Engineers Comments Regarding Surface Water Drainage

Application Reference:	AL/6/25/DOC	Reviewer Reference:	ADC/SB
Planning Officer:	Hannah Kersley	Date of Review:	21/02/2025
Site Name:	8 Autumn Gate Hook Lane Aldingbourne PO20 3TE		
Application Description:	Approval of details reserved by condition imposed under reference AL/75/24/HH relating to condition number 4 - surface water drainage scheme.		
Assessment Number:	1 of 2

Response	Condition 4: Objection
-----------------	-------------------------------

RAINWATER DOWNPIPE DRAINAGE INTO PERMAVOID RAFT
SCALE 1:15

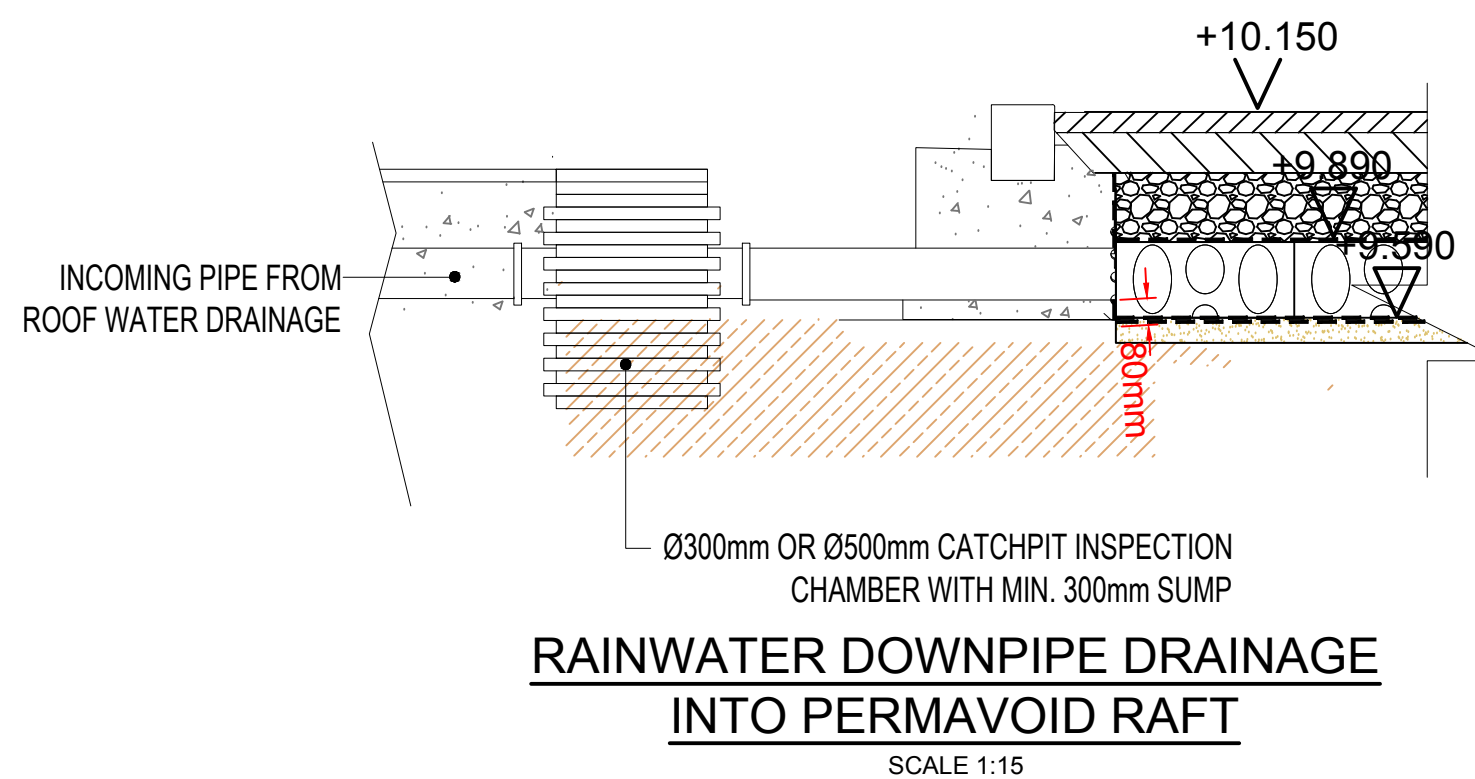
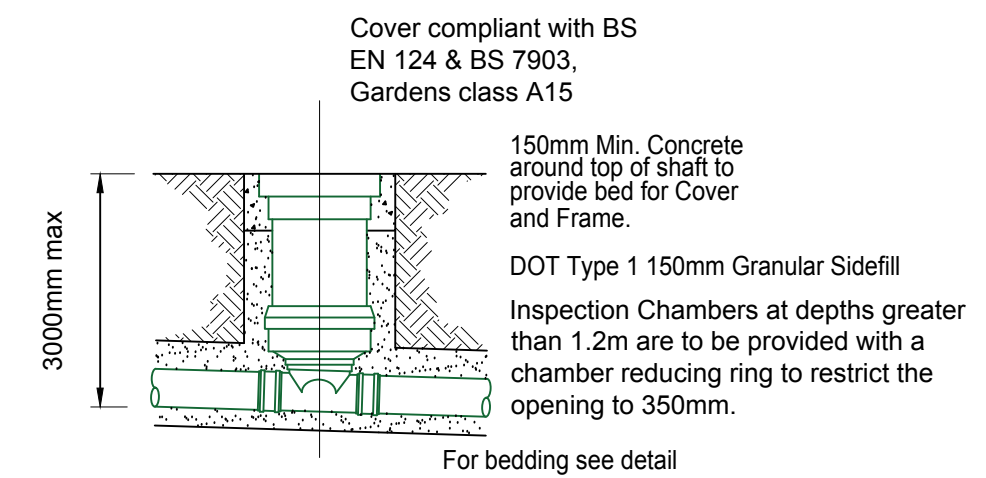
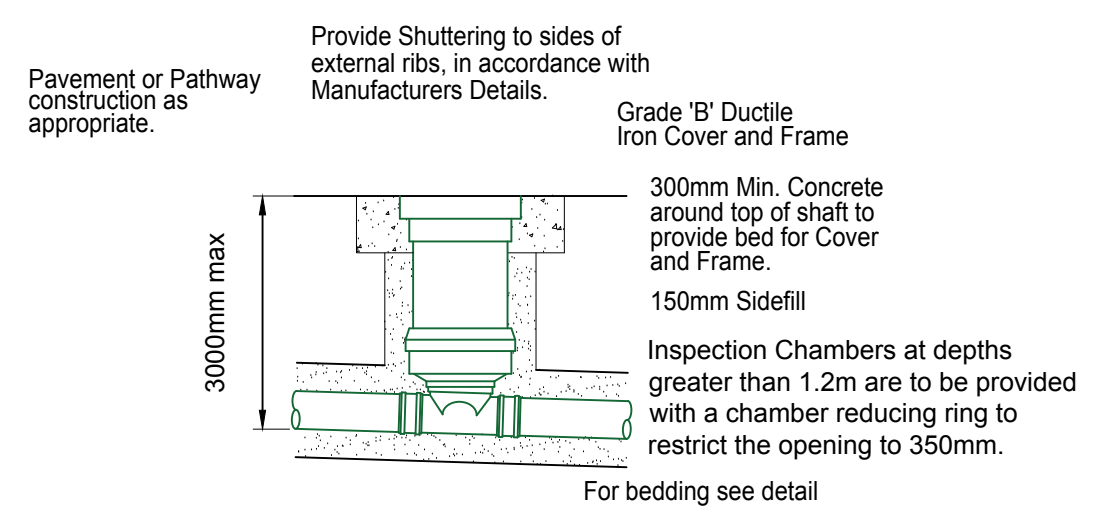
- ☒ Construction detail drawings are site specific. **May need additional – proposed extension specific**
- ☐ Construction detail drawings are provided for all components including but not limited to:

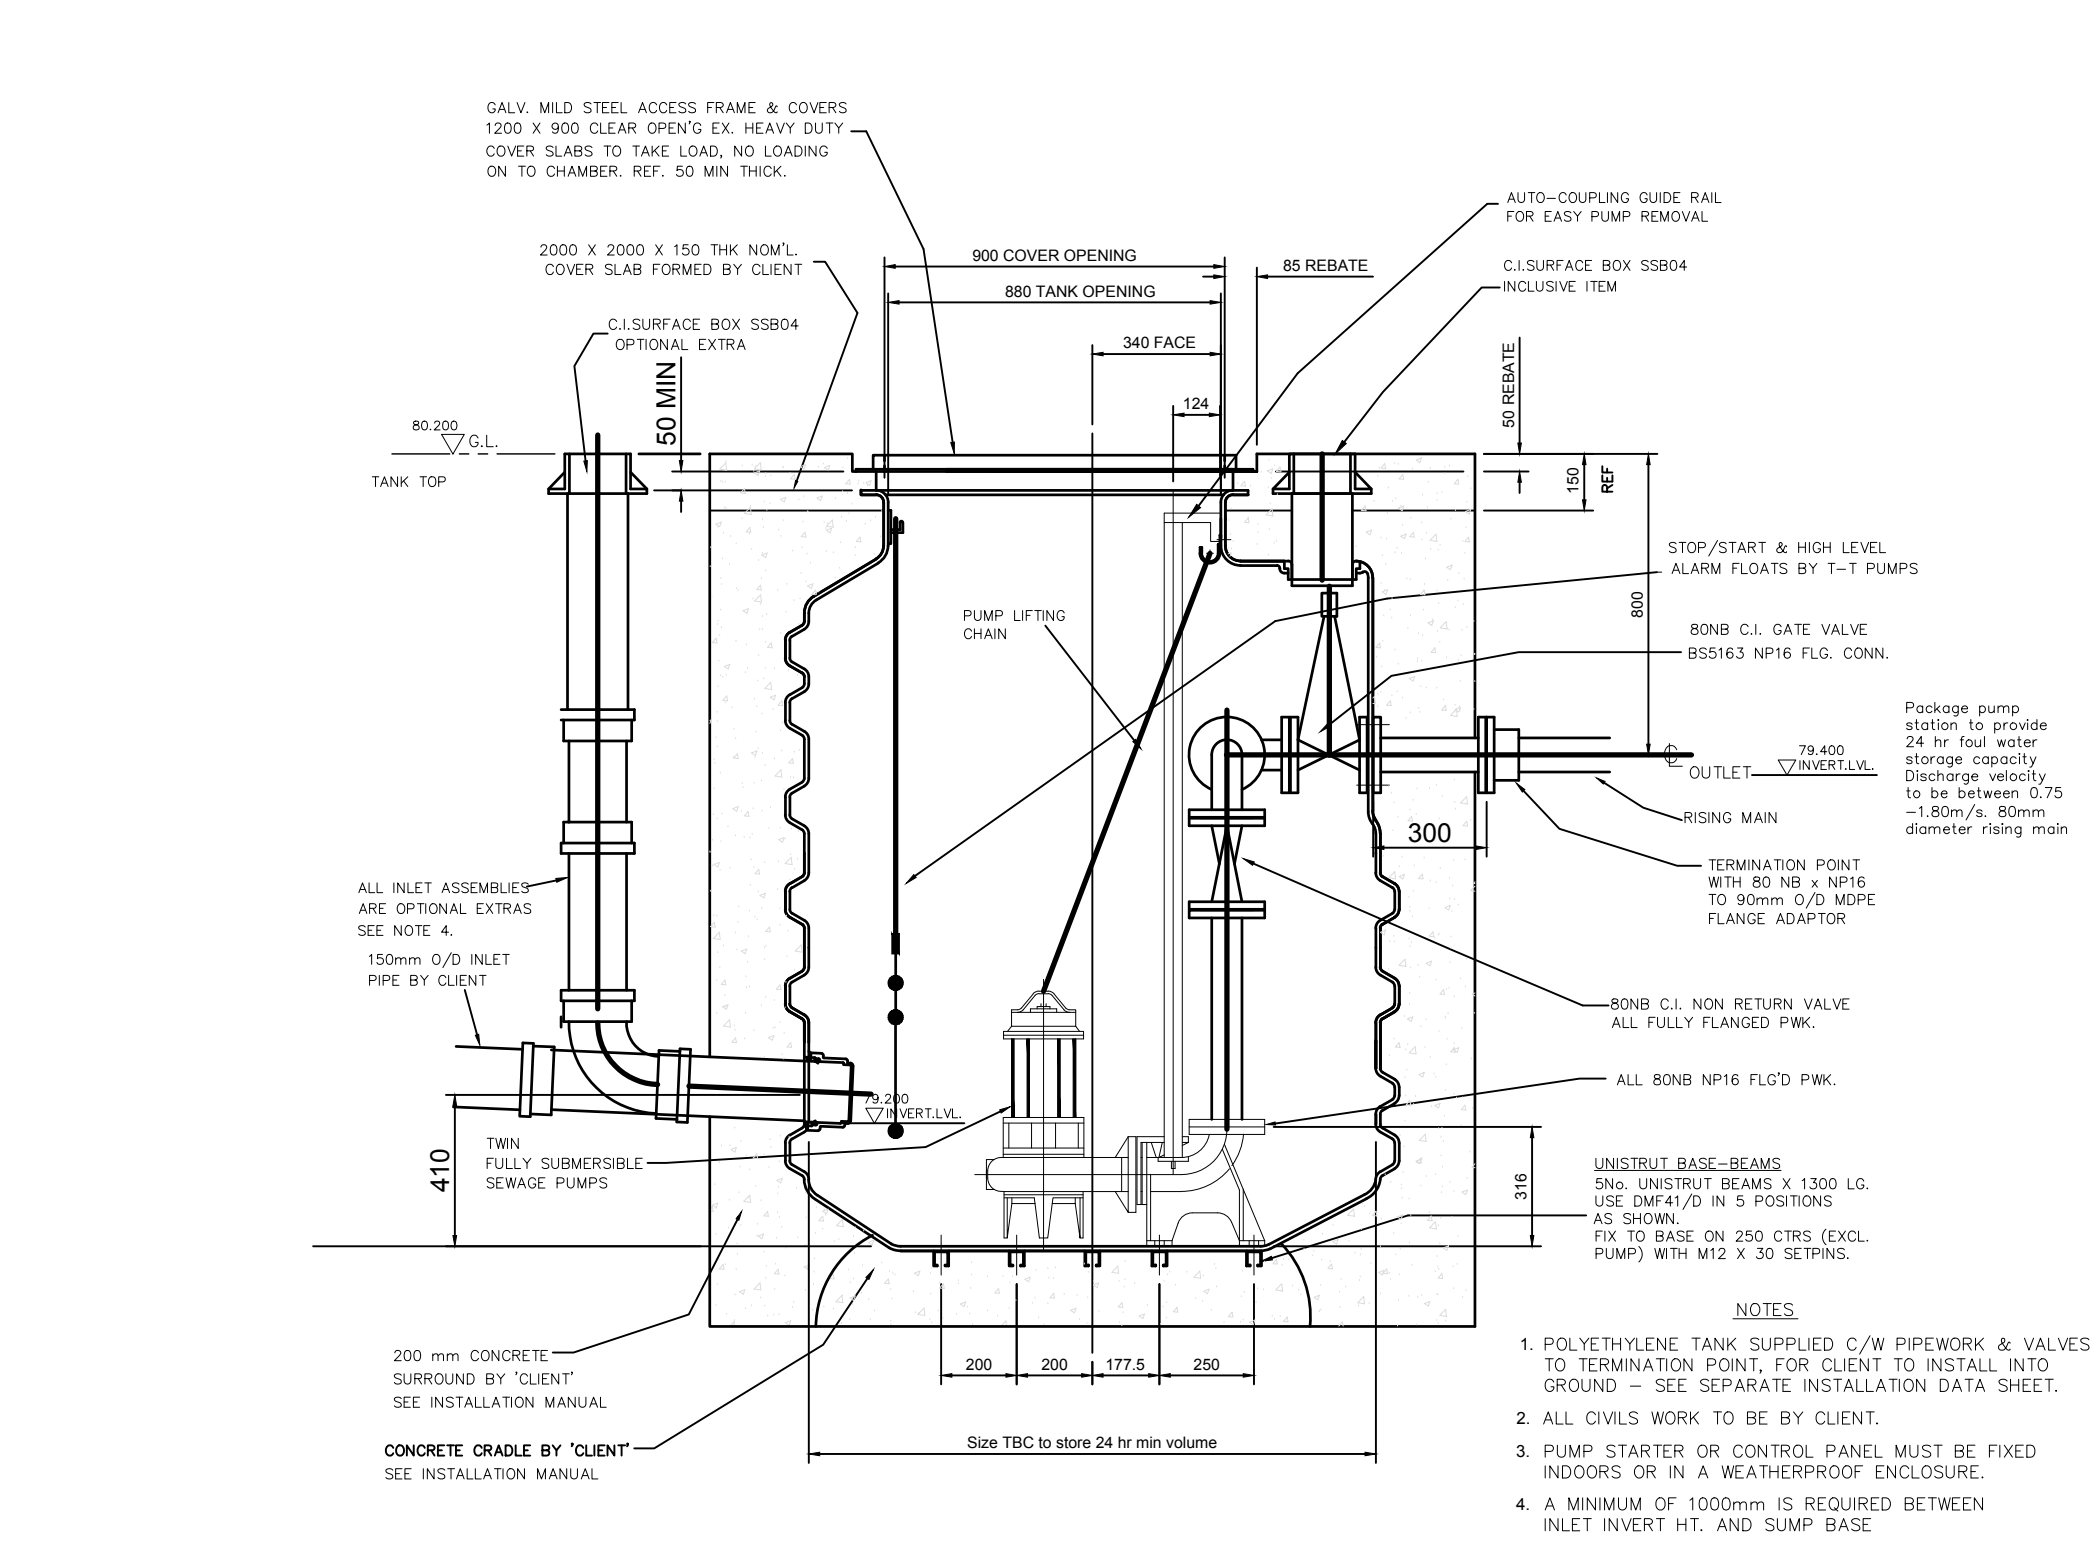
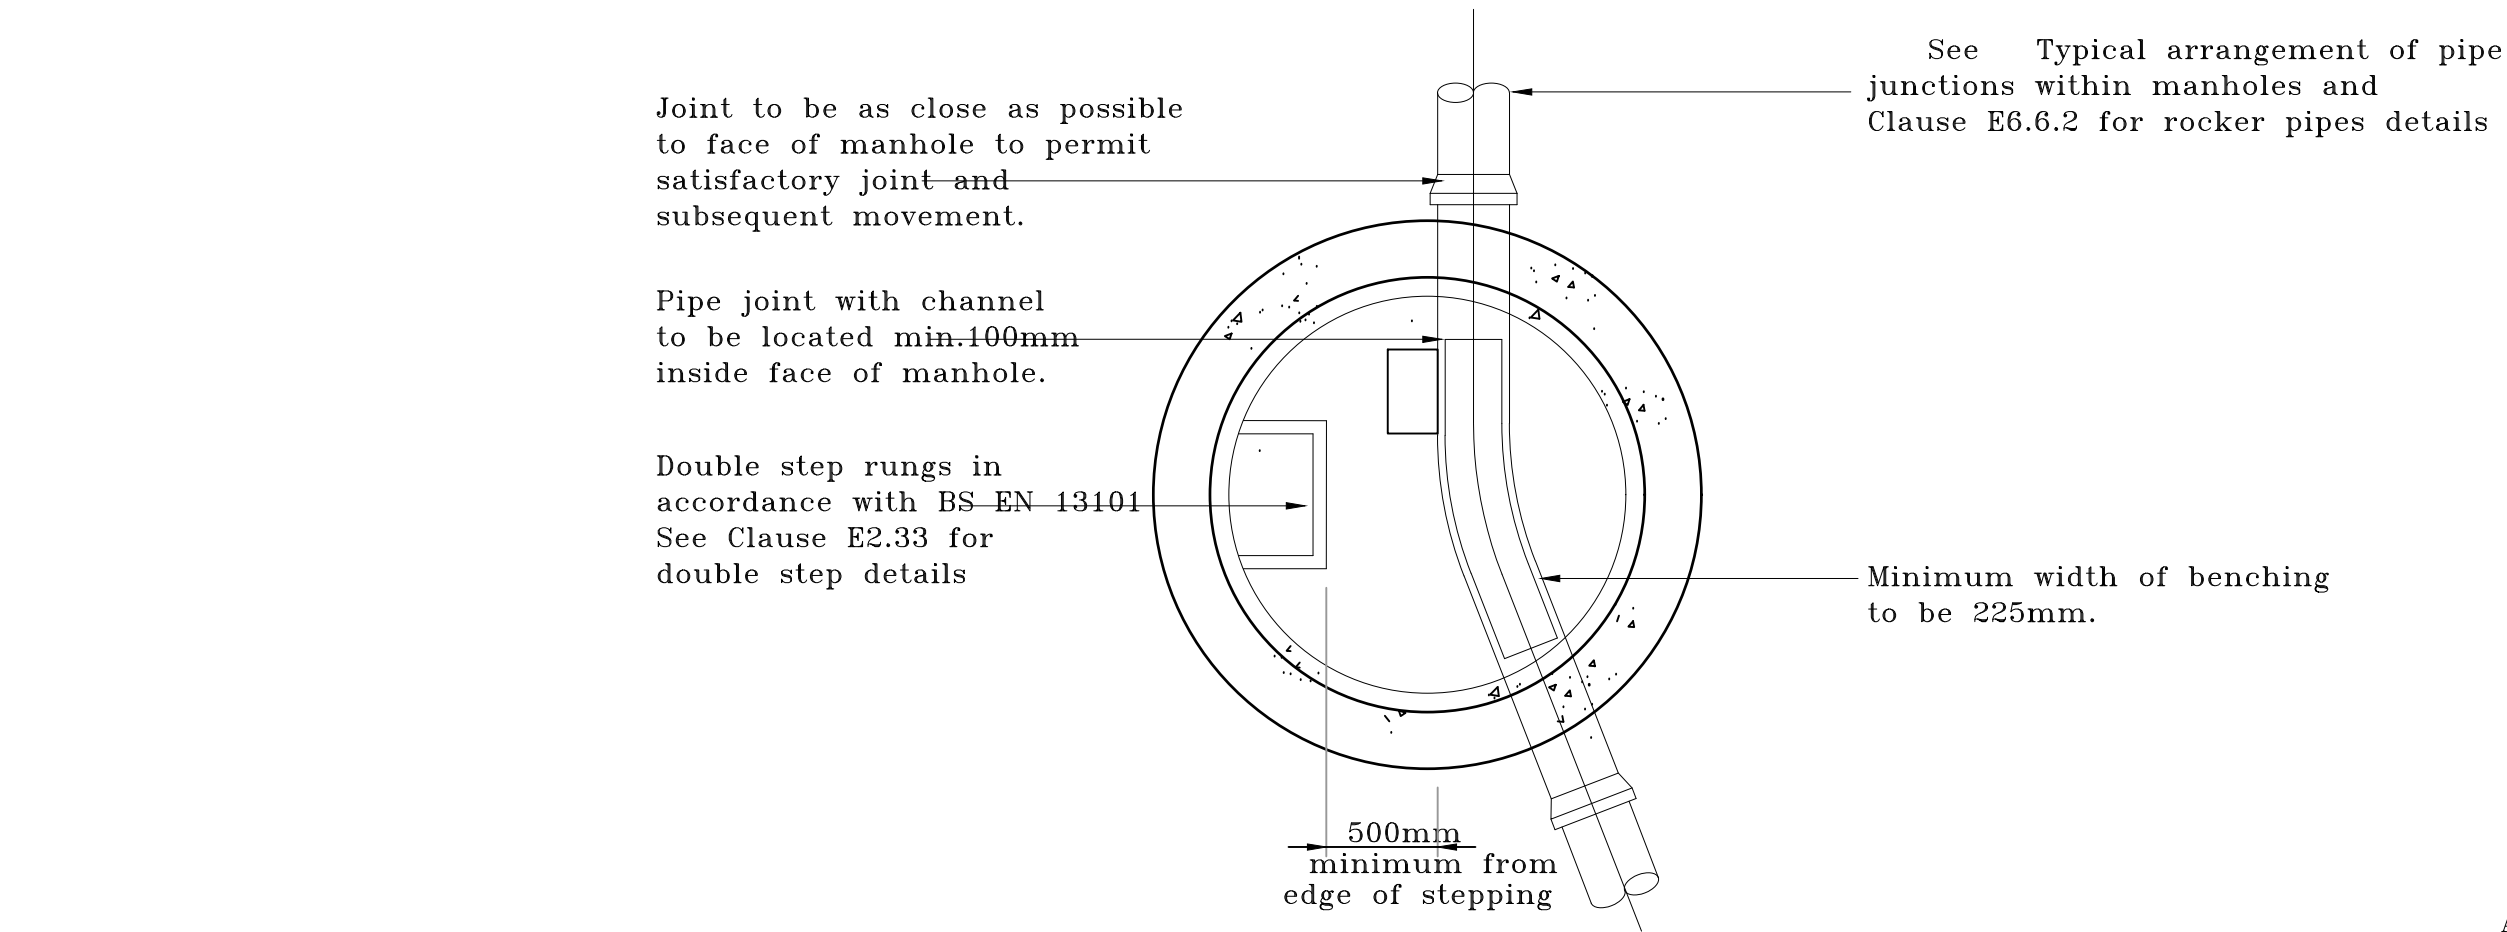
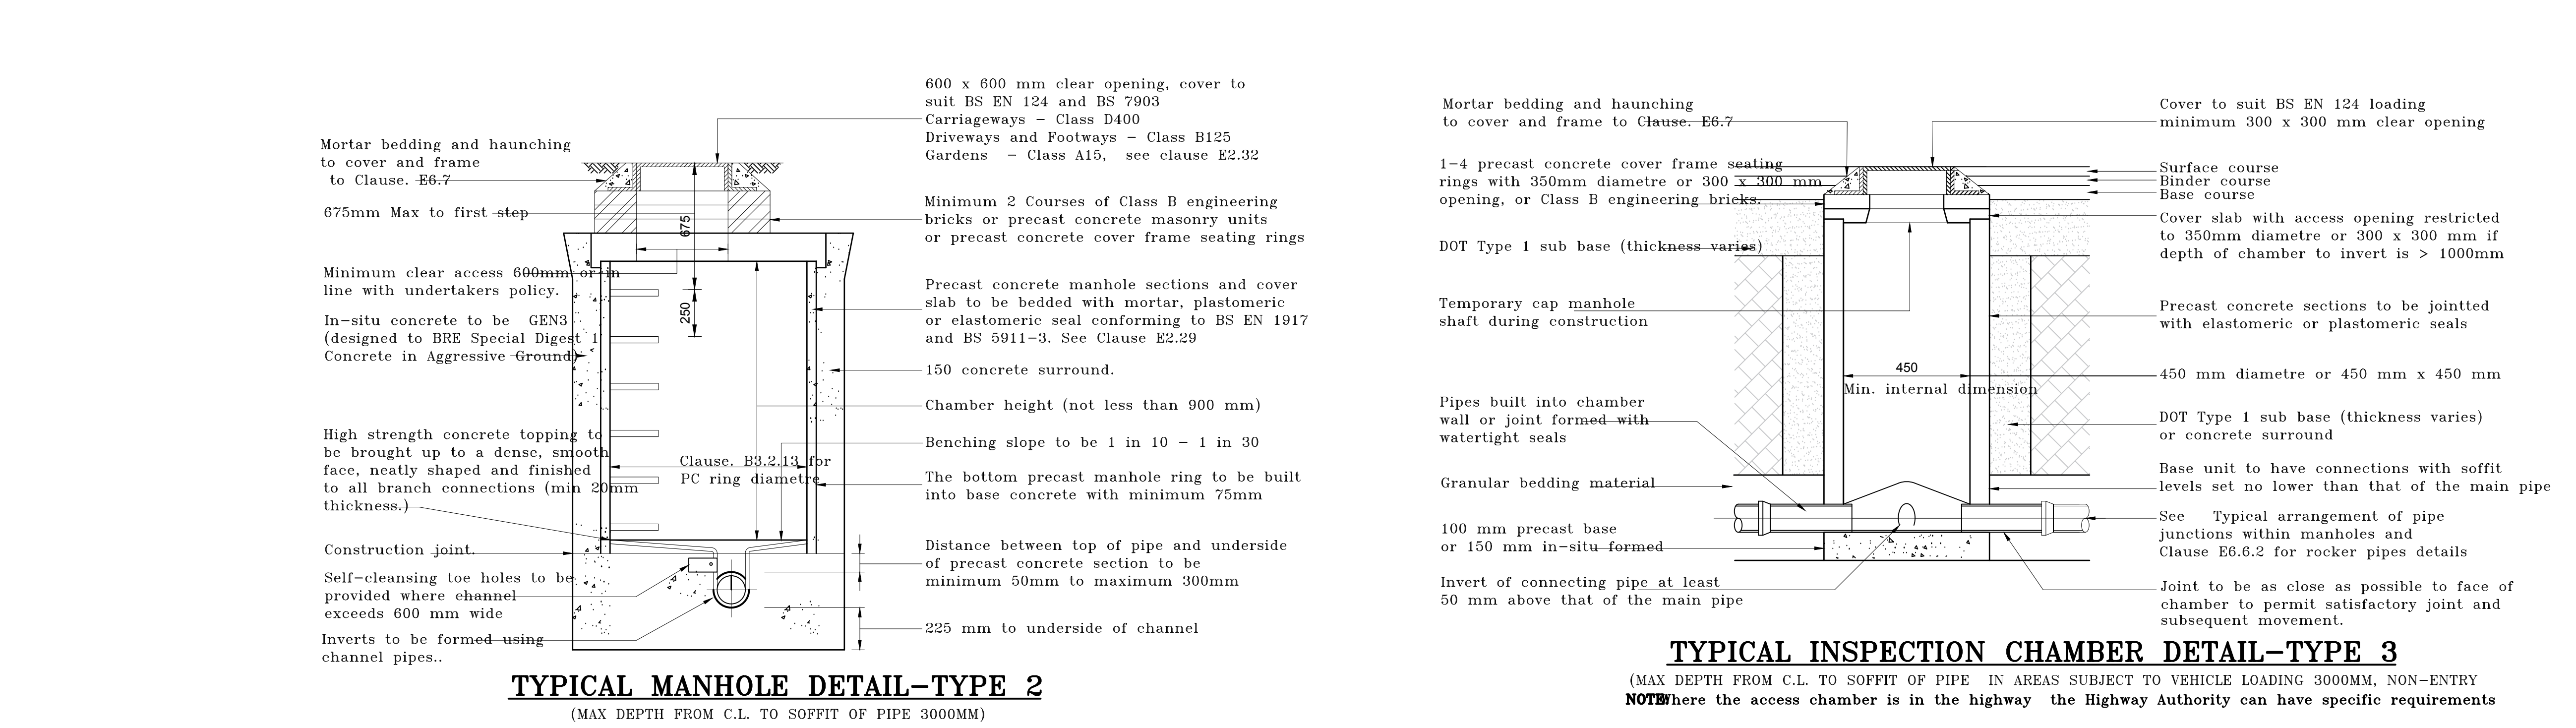
- Groundwater Monitoring Letter Report Ref GWPR4064
- Ordinary Watercourse Land Drainage Consent number LDC/ARUN/2021/013
- 435050-202 Rev P2 – Drainage Layout 2 of 2 – **the approved plan is a later revision [P5]**
- 435050-203 Rev P4 – Drainage Details 1 of 2
- 435050-204 Rev P – Drainage Details 2 of 2
- 435050-205 Rev P2 – Ditch Sections
- 435050-206 Rev P1 – Headwall Details – **the approved plan is a later revision [P2]**
- SW Network (Surcharged Outfall) dated 06/10/2021
- SW Network (435050 – FLOW SW) dated 28/08/2021
- SuDS Maintenance & Management Plan ref TB/435050/eg dated 11 October 2021
